**KIRKLEES METROPOLITAN COUNCIL  
INVESTMENT & REGENERATION SERVICE**

Reference No:	<b>2024/62/90279/E</b>
Site Address:	adj, Parsonage House, Edge Road, Thornhill Edge, Dewsbury, WF12 0QD
Description:	Erection of detached dwelling
Recommending Officer:	Nina Sayers

**DECISION - REFUSE**

## **Officer Report**

PROPOSED NEW CONTEMPORARY HOUSE ADJACENT TO
 PARSONAGE HOUSE EDGE ROAD THORNHILL EDGE DGBURY
 WF12 0QR FOR MR. & MRS. S BROUGHAM MAY 2024

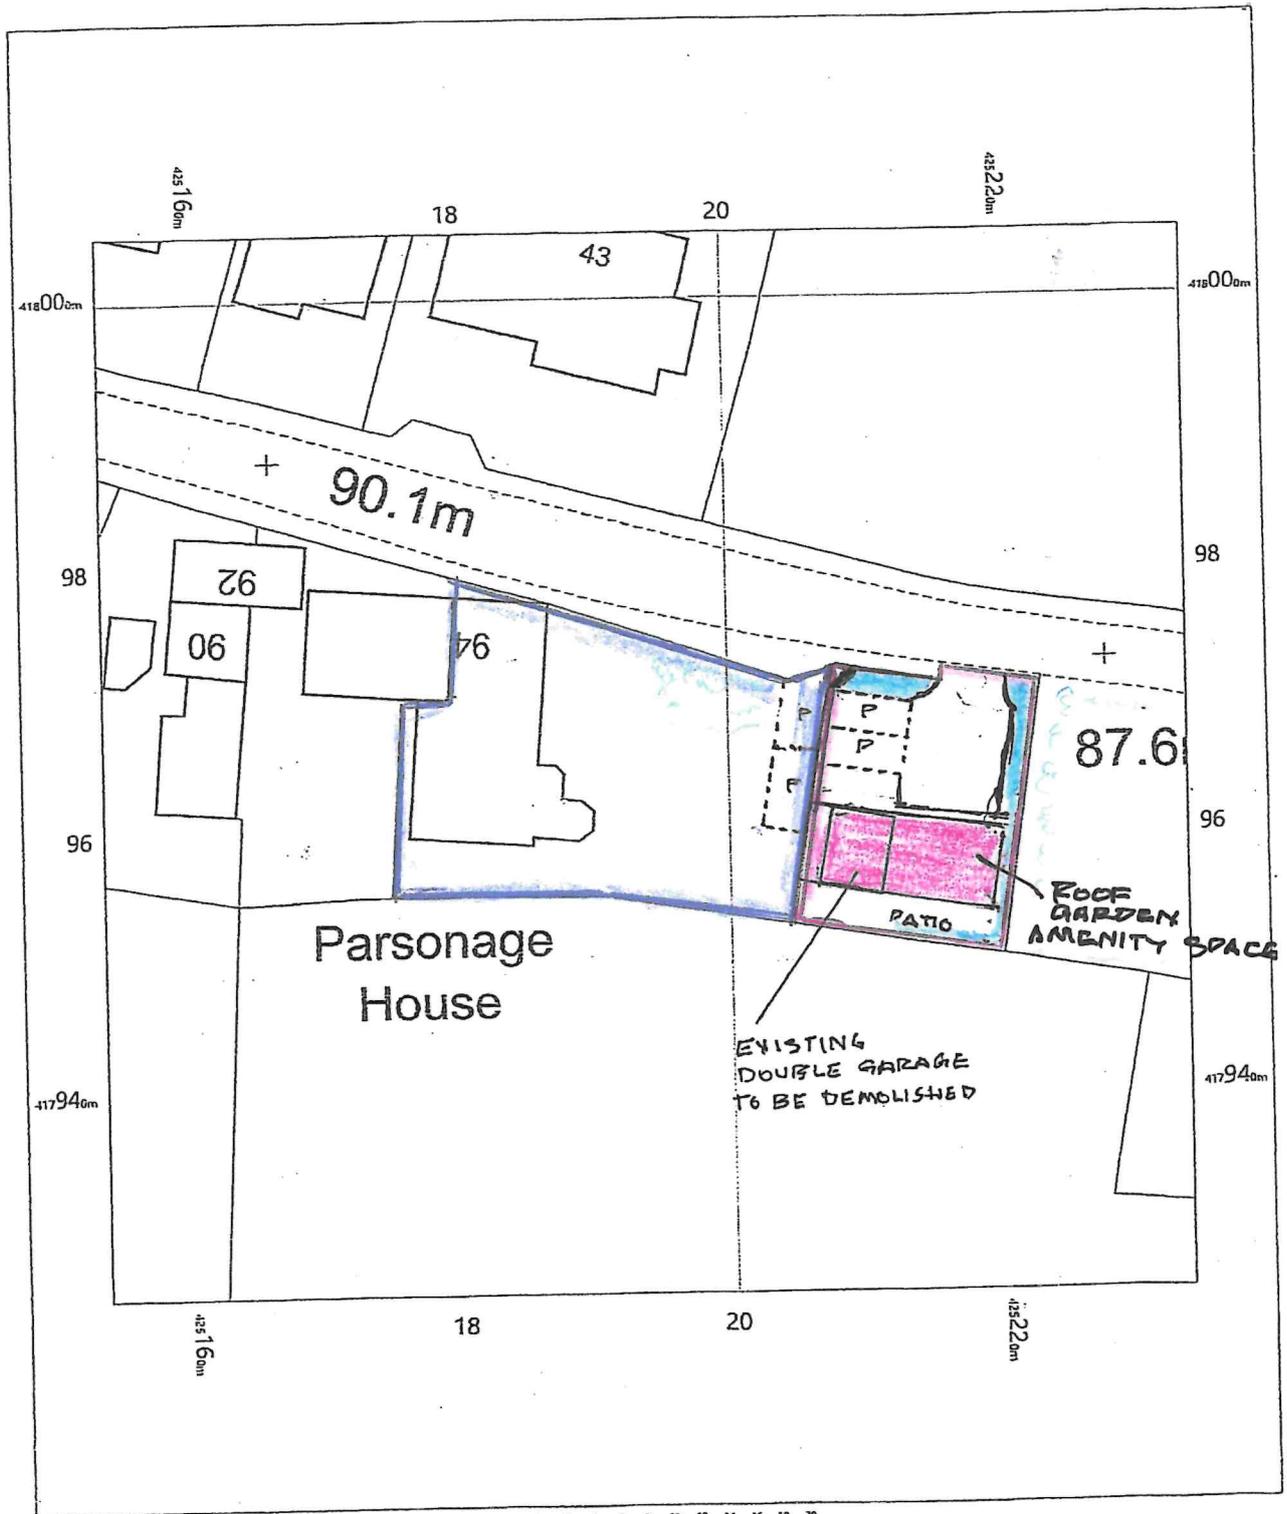
The scheme proposes one dwelling with potential for three bedrooms. The Kirklees Highways Design Guide SPD states that at least 2 on-site spaces are required for dwellings with 3 bedrooms. The proposed site plans show off-street parking provision for two vehicles in the driveway. KC Highways Development Management (HDM) raised concerns regarding the proposed parking spaces as they are insufficient in length and sight lines onto Edge Road are poor. They also recommended that the width of the proposed driveway is widened to 6.0m to allow comfortable turning and manoeuvre.

The proposed dwelling would be built on the footprint of the existing garage and parking provision for Parsonage House, therefore KC HDM requested off-street parking provision was also demonstrated for Parsonage House.

An amended site plan was provided which demonstrated parking provision for both properties and a separate access onto Edge Road for the existing dwelling. These were reviewed by KC HDM who requested a 2.4 x site frontage site line was from the proposed access and the existing telegraph pole need to be re-sited. As the principle of development is considered

ROOF GARDEN-PRIVATE AMENITY SPACE

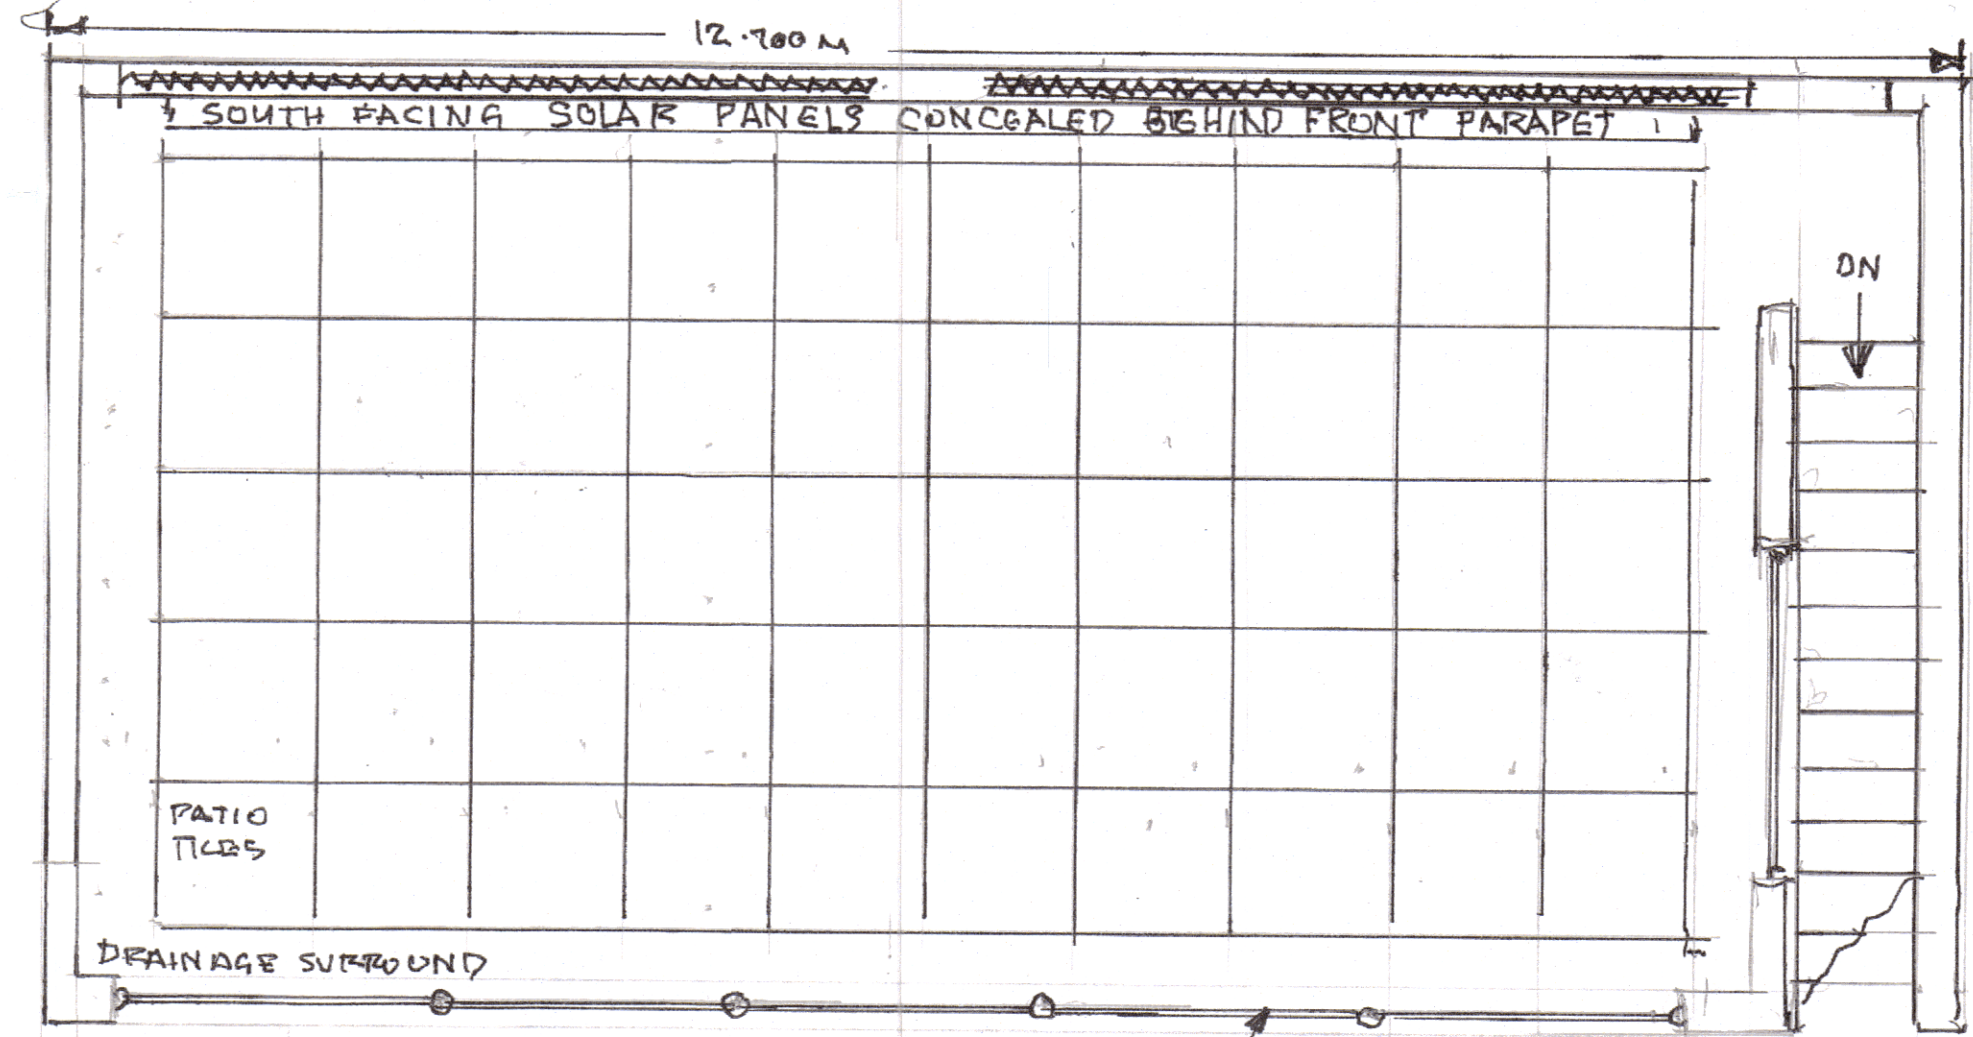
There would be amenity space proposed on the roof of the proposed dwelling which could result in overlooking harm to the occupants of Parsonage House. Should this application be approved, it would be recommended that a condition is imposed to ensure there is screening to the western side of the amenity space to prevent overlooking harm.

FRONT ENTRANCE NORTH ELEVATION

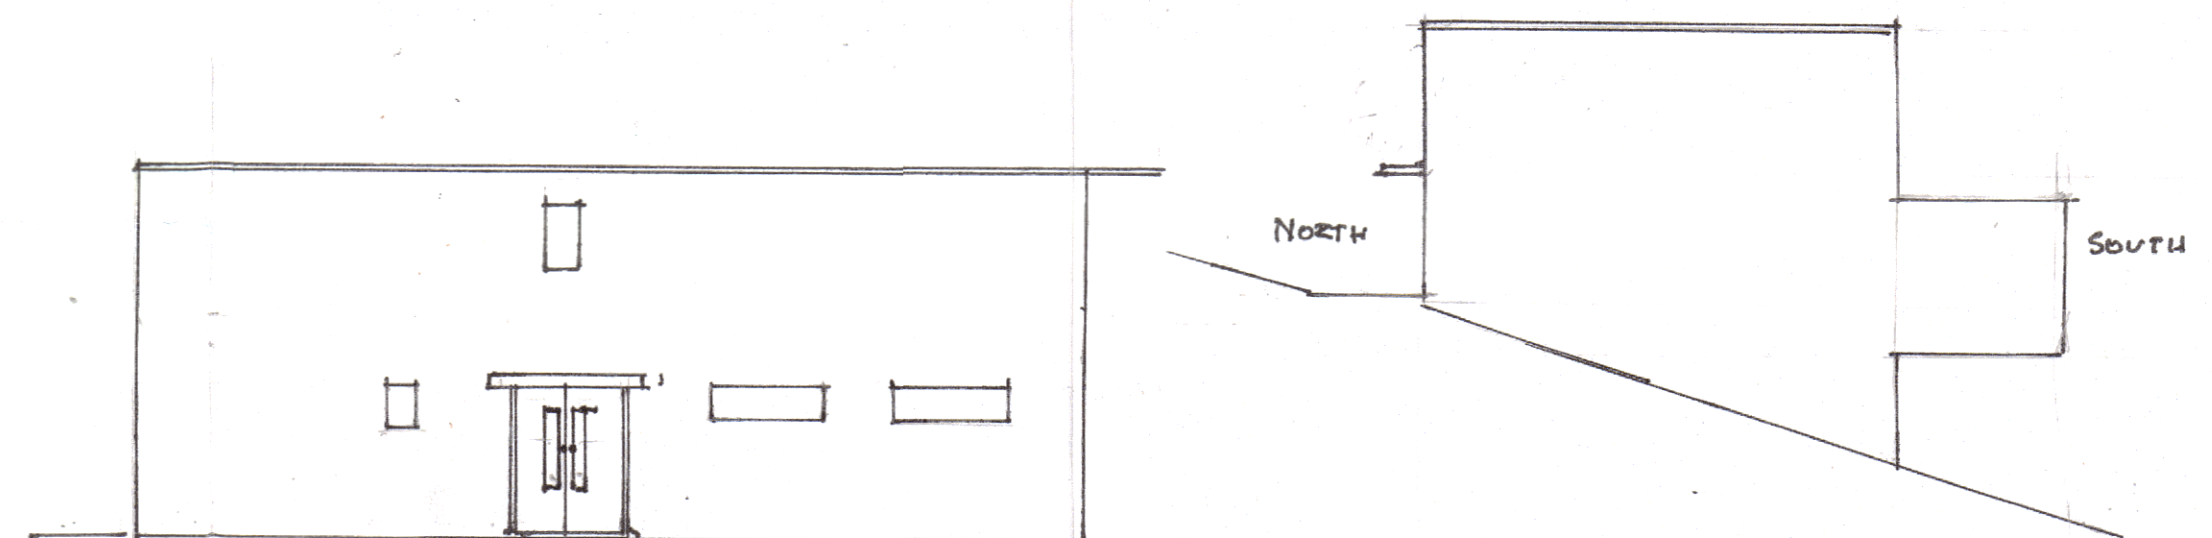
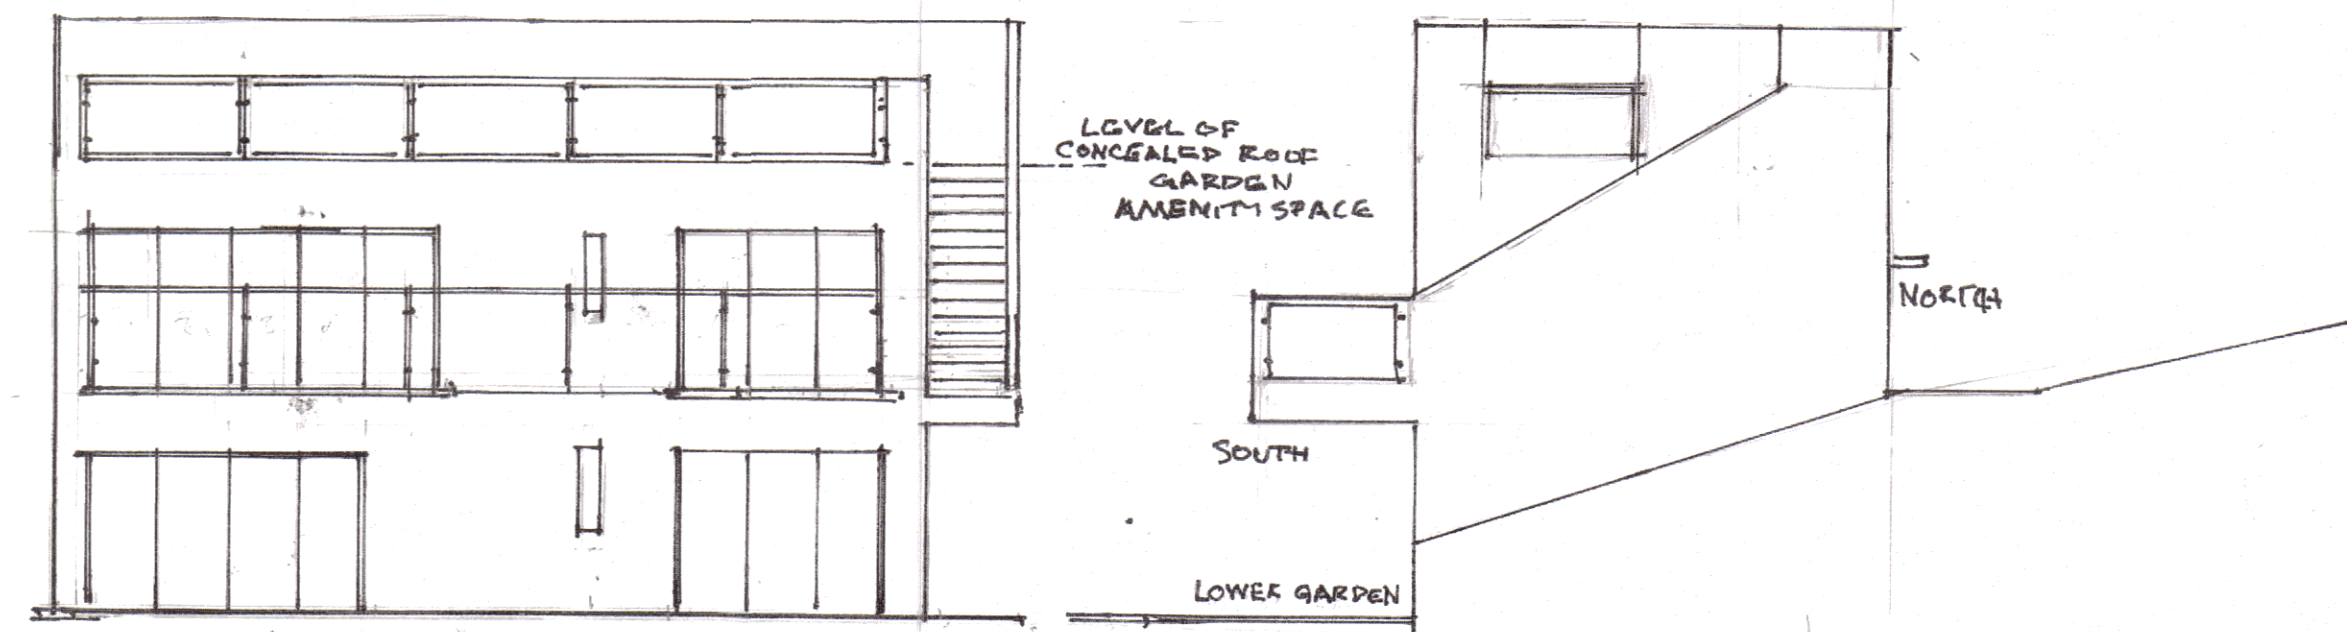
The proposed development would be of a contemporary design, with a flat roof finished in stone facing and monocouche render. The existing Parsonage House is a traditional pitched roofed, stone faced dwelling. It is noted that within the street scene the existing dwellings vary in terms of design and materials although they are primarily finished in stone with clad features and the roof types are pitched. The proposed flat roofed design, and render finish would therefore not be in keeping with the existing street scene.

The existing building line is staggered, however the properties generally front the highway. The proposed dwelling would be set back significantly from the highway and would not align with the existing development. It is noted that the proposal would be set back and down from the highway, thus somewhat reducing its prominence. However, no site section or street scene plan have been submitted with the application to demonstrate if the dwelling would be set below visibility from the highway. Therefore, based on the information available to officers there is no evidence to demonstrate that the proposed contemporary design would not cause harm to the street scene.

Notwithstanding the concerns raising in the principle of development section of this report, the proposed dwelling, by virtue of design and materials, would not be in keeping with the existing built development and as a result would cause harm to the visual amenity of the area. The proposal fails to accord with Principle 2 of the Housebuilders Design Guide SPD, Policy LP24(a) of the Kirklees Local Plan and Chapter 12 of the NPPF.
